Elizabeth Drive Subdivision (SSD 8859) – Elizabeth Drive Cecil Park

The proposal seeks approval for carrying out enabling works to facilitate the development of the Elizabeth Drive Business Hub including subdivision the subject land into 14 allotments. The documentation in support of the proposal is reviewed and our comments are summarized in **Attachment A** for consideration. Our recommended conditions of consent are outlined in **Attachment B**.

CD19/00866

LEGEND		Figure 15: Vehicular Network
	Site Boundary	
	Cadastre	
	Motorway	
	Existing Road Network	
	Proposed 20.0m Wide Access Road	
	Proposed 13.0m Wide Deceleration Lane

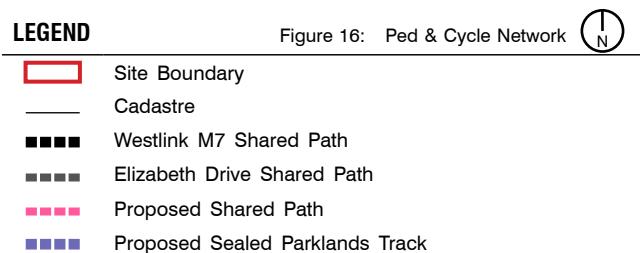
The EIS and traffic report have indicated that construction of a new shared pathway should be considered. Figure 6 in the EIS has indicated that footpath and cycle path will be provided along the site boundaries interfacing Elizabeth Drive. The traffic report states that this new shared pathway along the northern side of Elizabeth Drive, past the site frontage, will connect to the Westlink M7 shared path. However, as shown in various figures in both reports, it is not evident how the proposed new shared path will interact

Clarification is needed to demonstrate how the proposed new shared path will interact with the proposed deceleration lane and connects with the Westlink M7 shared path. It is also requested that the proposal should consider continuing the new shared path into Cecil Road across the frontage of the proposed Lot 1 and 2.

Figure 17: Access Street (20.0m Road Reserve)

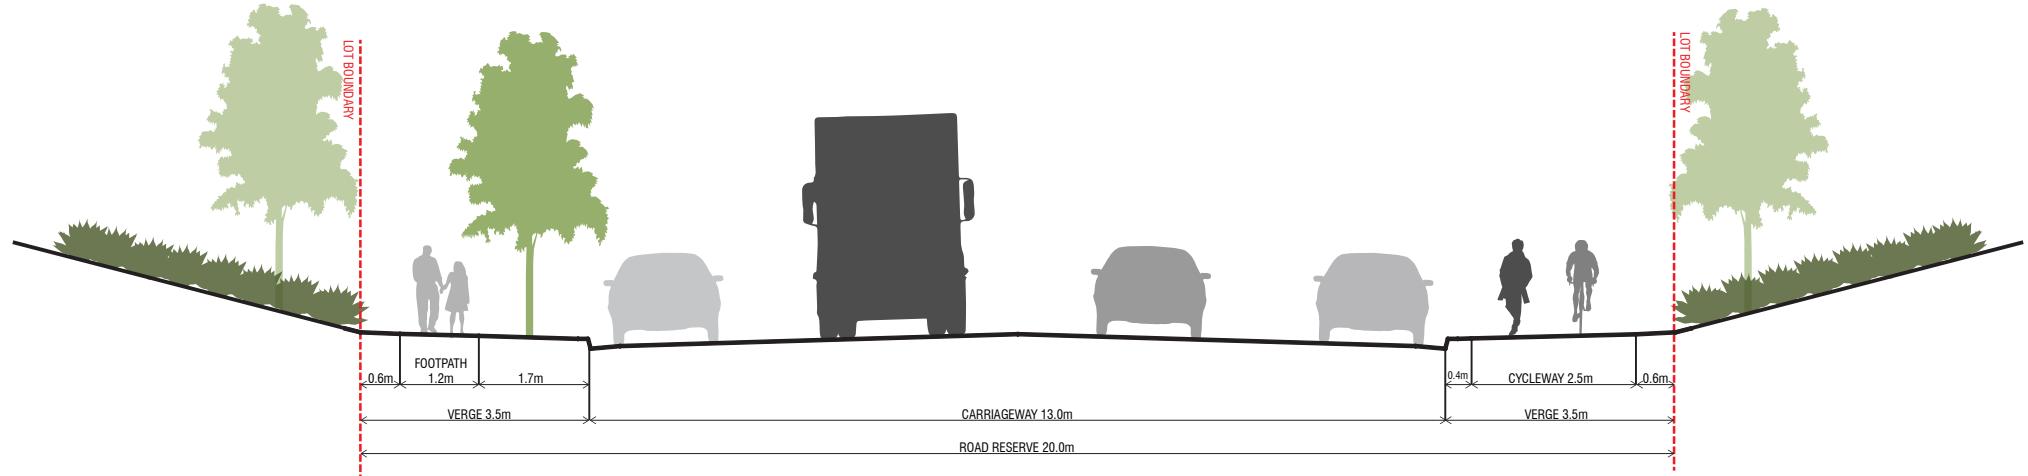
The traffic report assumes that a large rigid truck is the largest commercial vehicle size that would access the local road which connects to Cecil Road.

Giving consideration to the nature of the proposed development and the location of the site with regard to the motorways, it is recommended that the internal road should be designed to at least accommodate larger commercial vehicle size i.e. B-Double or bigger.
